Ribble Valley Borough Council
Housing & Development Control

Application no: **3/2023/0038**

Address: **Brentwood Pendleton Road Wiswell BB7 9BZ**

Proposal: **Proposed new vehicular access.**

# Brentwood Site Plan

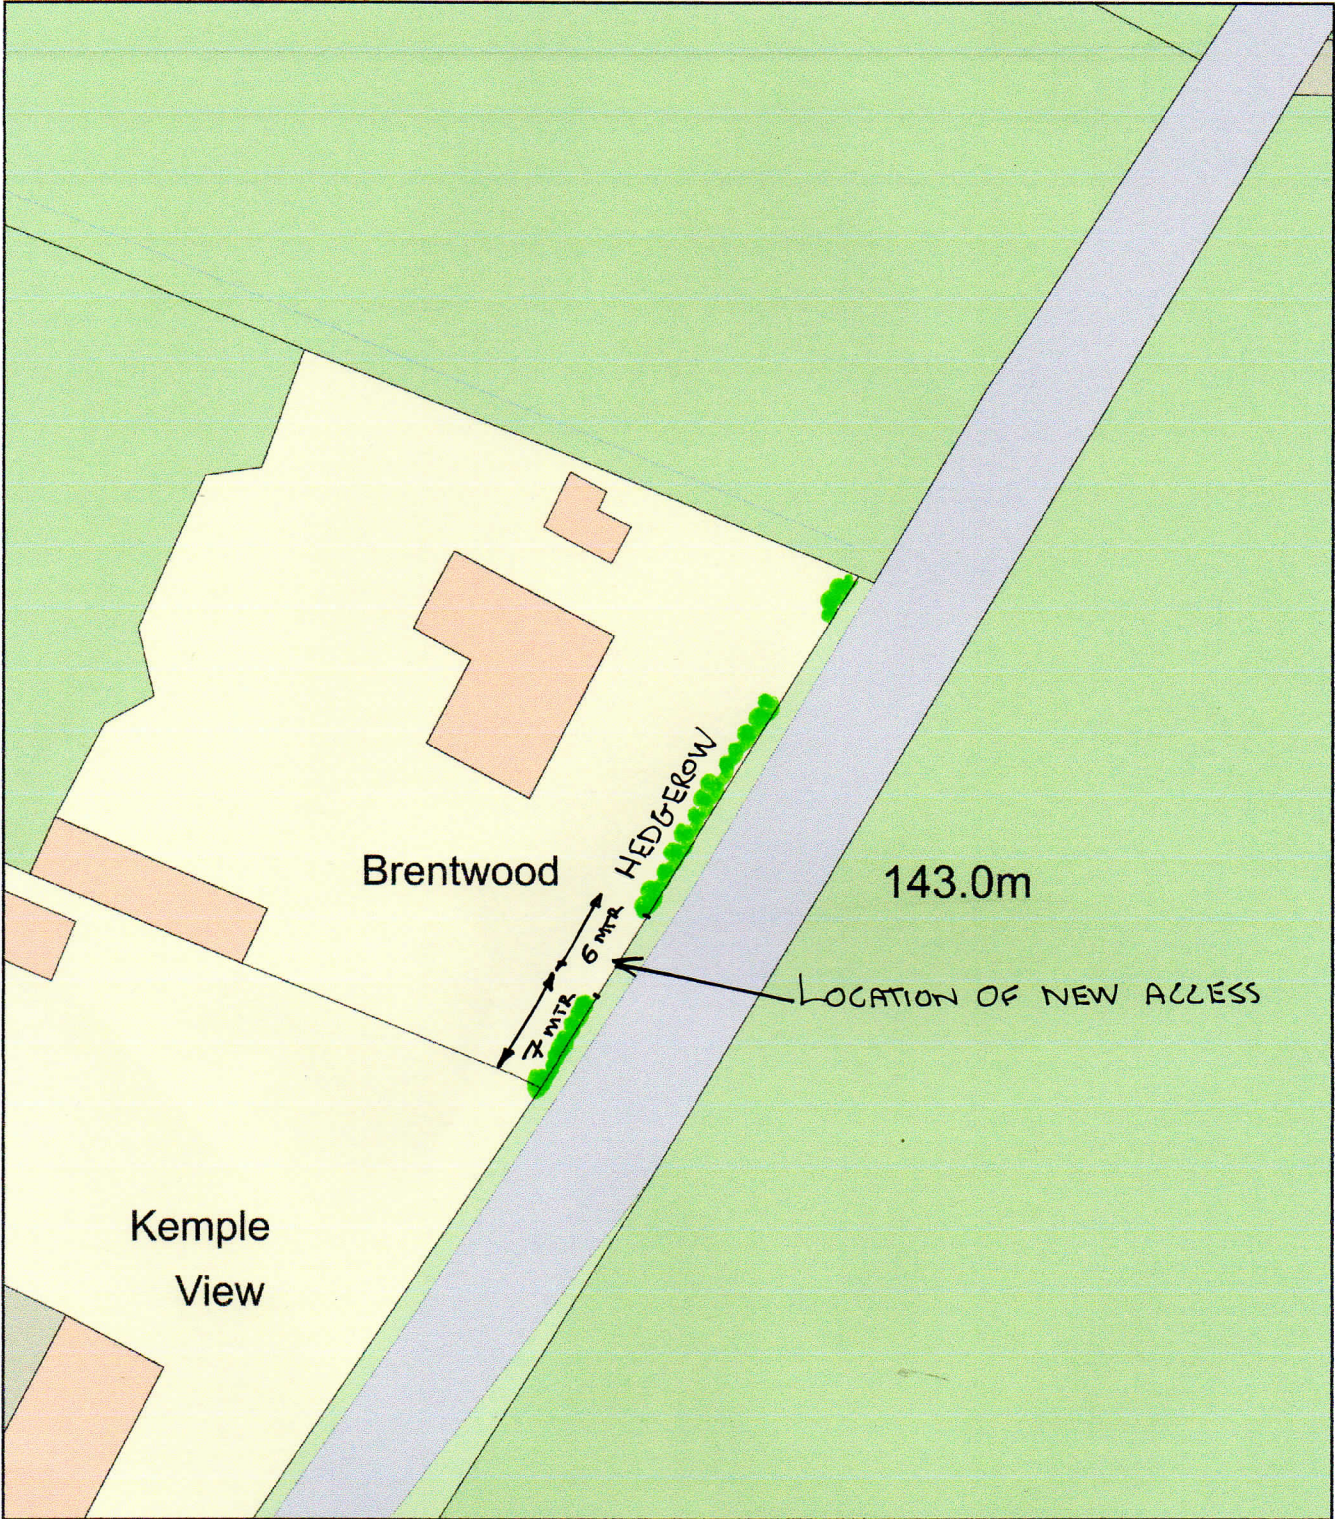
In any case, the LHA have reviewed the amended drawing titled "Amended Site Plan" and are aware that the proposed access has been relocated 7m from the southern boundary of the site. The access will remain 6m wide which complies with the LHAs guidance when serving a single dwelling.

However, by reviewing the visibility splays, the LHA are aware that both sets of splays overlook the neighbouring dwellings land in both directions which is unacceptable.

Usually, the LHA would request that the visibility splays are redrawn before the application is determined. But in this case the LHA will place a suitable condition on the application for a revised visibility splay drawing to be submitted should the application be permitted by the Local Planning Authority. This is because the visibility splays can be redrawn to the centre of the carriageway meaning that the splays will not overlook third party land. The Agent/ Applicant is able to do this because of Pendleton Road being a single-track carriageway and so the LHA are able to accept visibility splays to the centreline of the adopted highway.

1. No part of the development hereby permitted shall be occupied until such time as the access arrangements shown on drawing titled "Amended Site Plan" have been implemented in full.

2. No part of the development hereby permitted shall be occupied until such time as vehicular visibility splays of 2 metres by 43 metres have been provided at the site access. These shall thereafter be permanently maintained with nothing within those splays higher than 1 metres above the level of the adjacent footway/verge/highway.
